Project Name: LESTER

DRB CASE ACTION LOG (FINAL PLAT)

**CITY OF ALBUQUERQUE
PLANNING DEPARTMENT
April 23, 2008
DRB Comments**

RE: Lot B-1, Lester's Tract

SITE SKETCH  
**TRACTS B-1-A B-1-B**  
**MICHAELS MANOR NORTH**

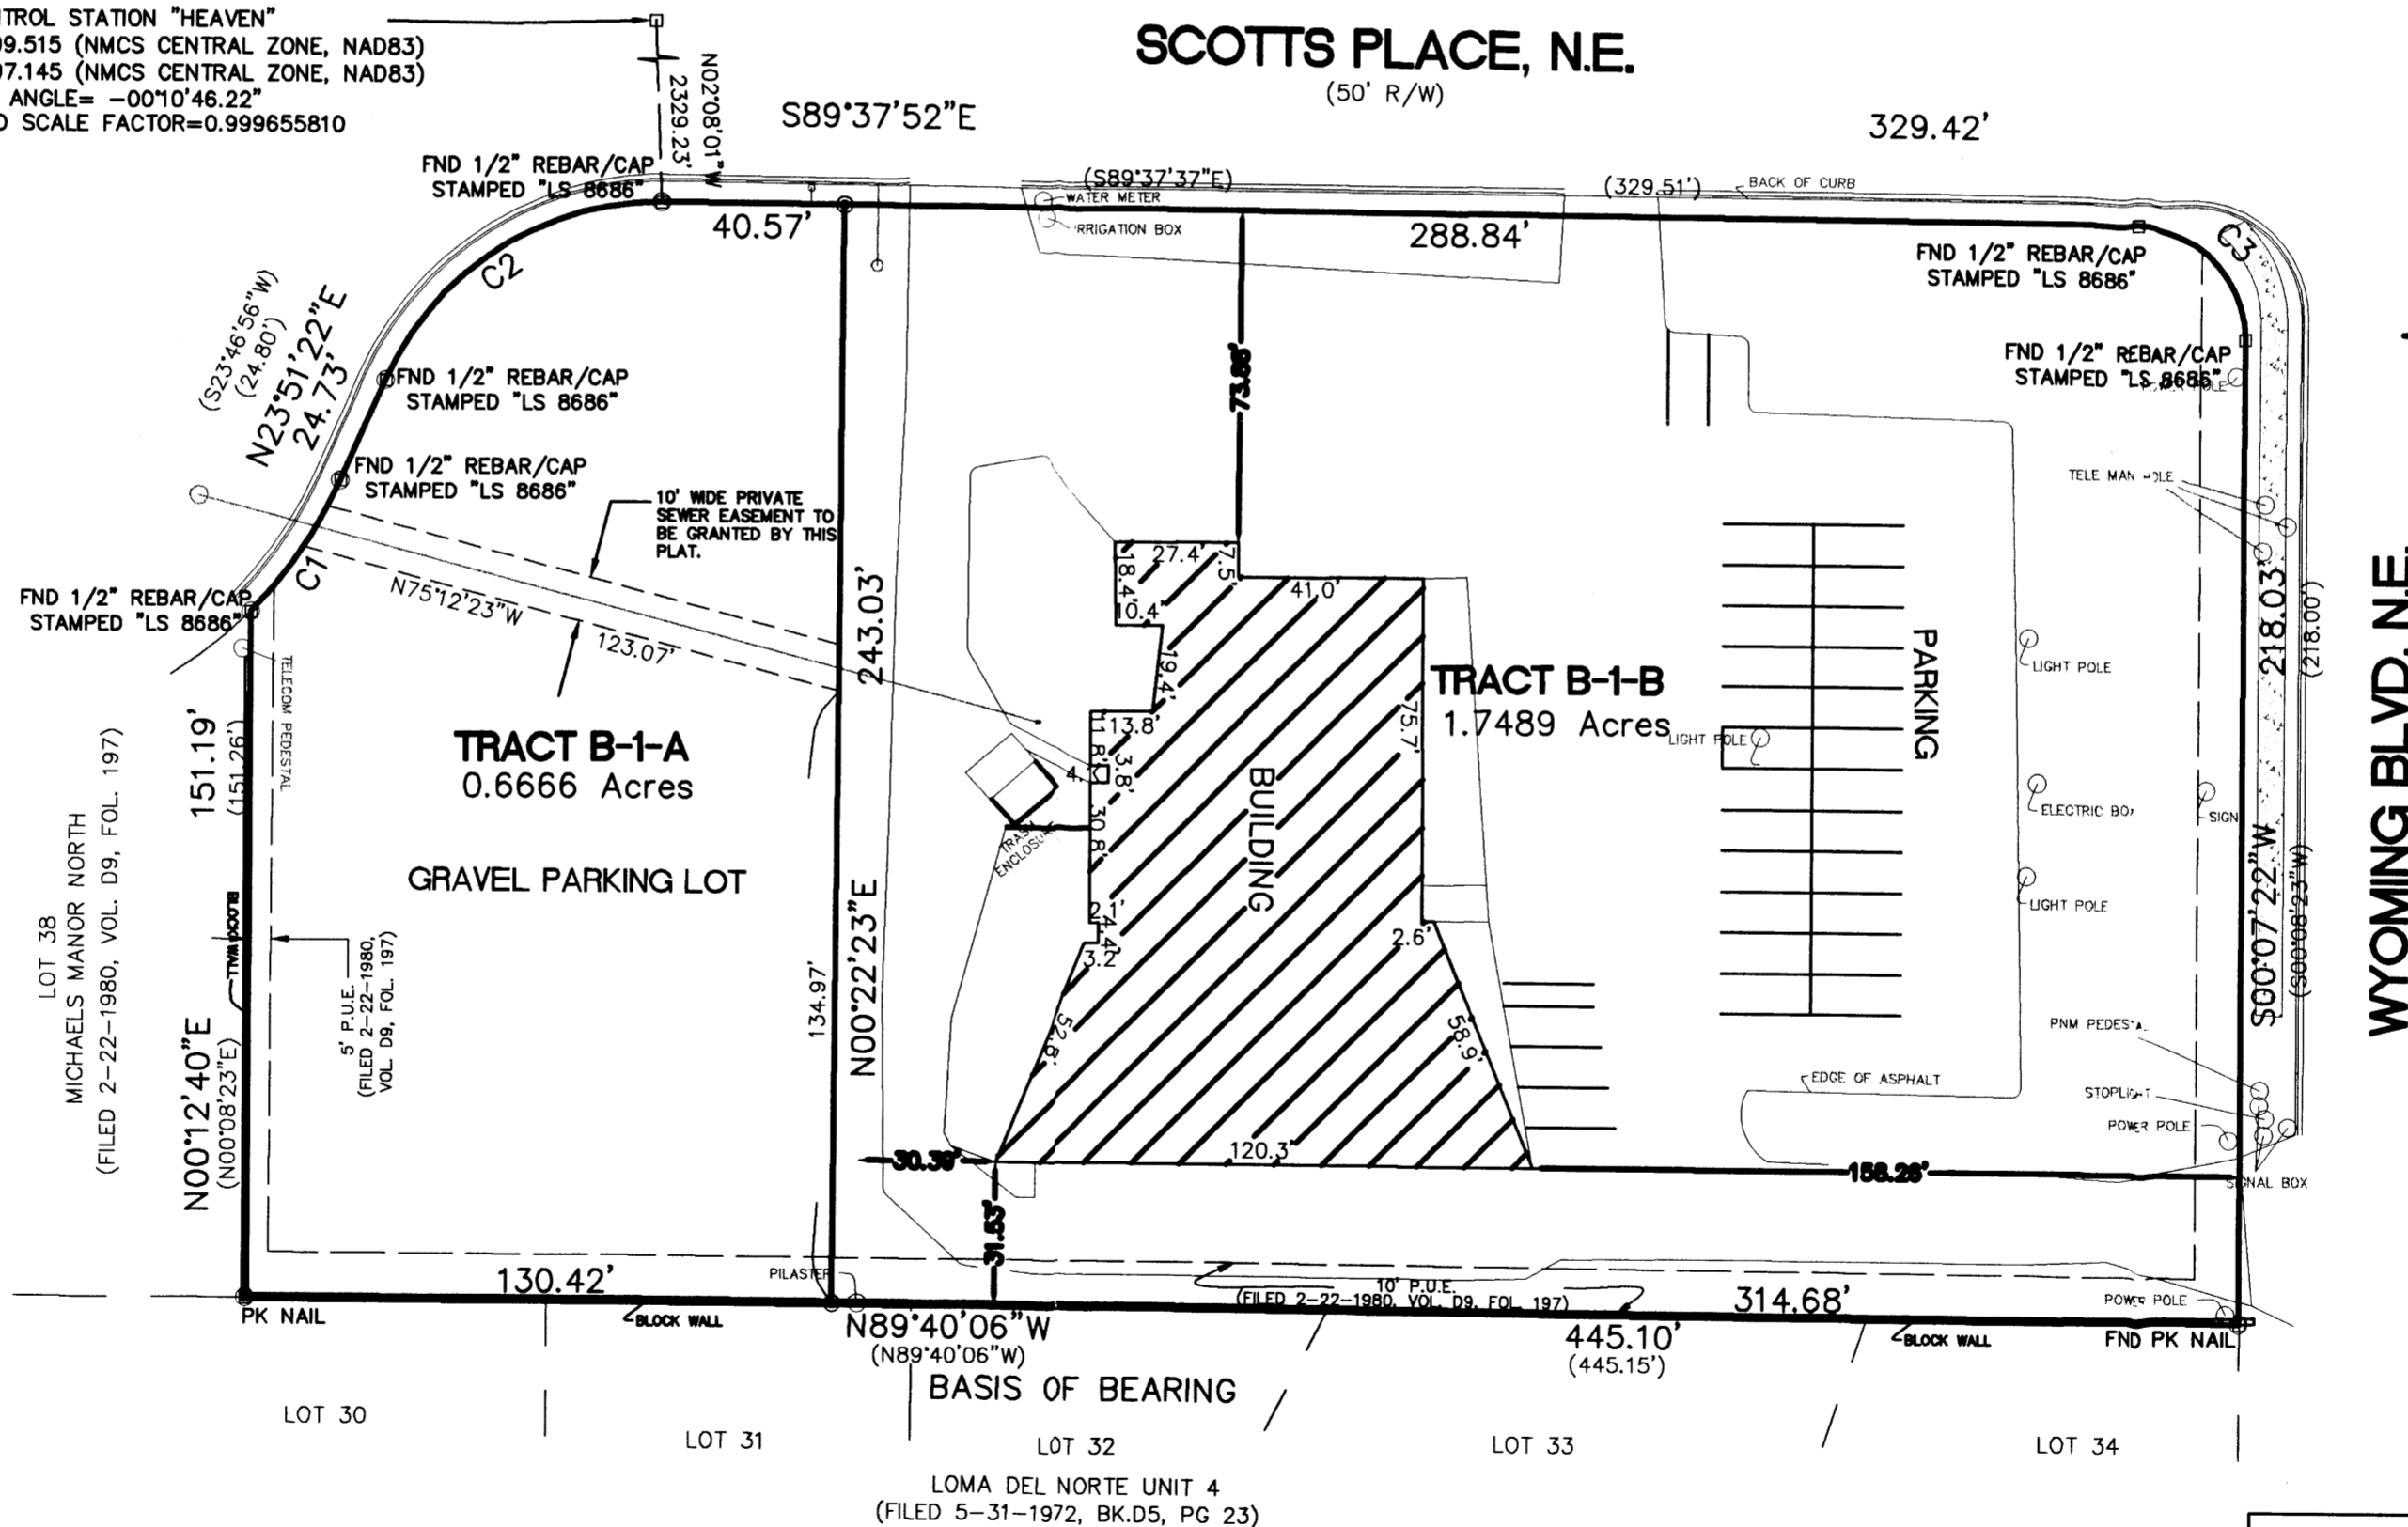
The plat may require a cross-lot drainage easement.

This site is zoned SU-1 – any platting must conform to an approved SITE DEVELOPMENT PLAN – the site plan would need to demonstrate adequate parking and circulation on the proposed smaller lot (shown as NEW LOT B-1-B) for the existing building.

1. There is no sewer line along the north edge of property in Scotts Place. There is a manhole near the north west corner of property and it is likely that the sewer service for the existing Mortuary goes to this line and not to Wyoming. Surveyor must determine where the sewer service line is.
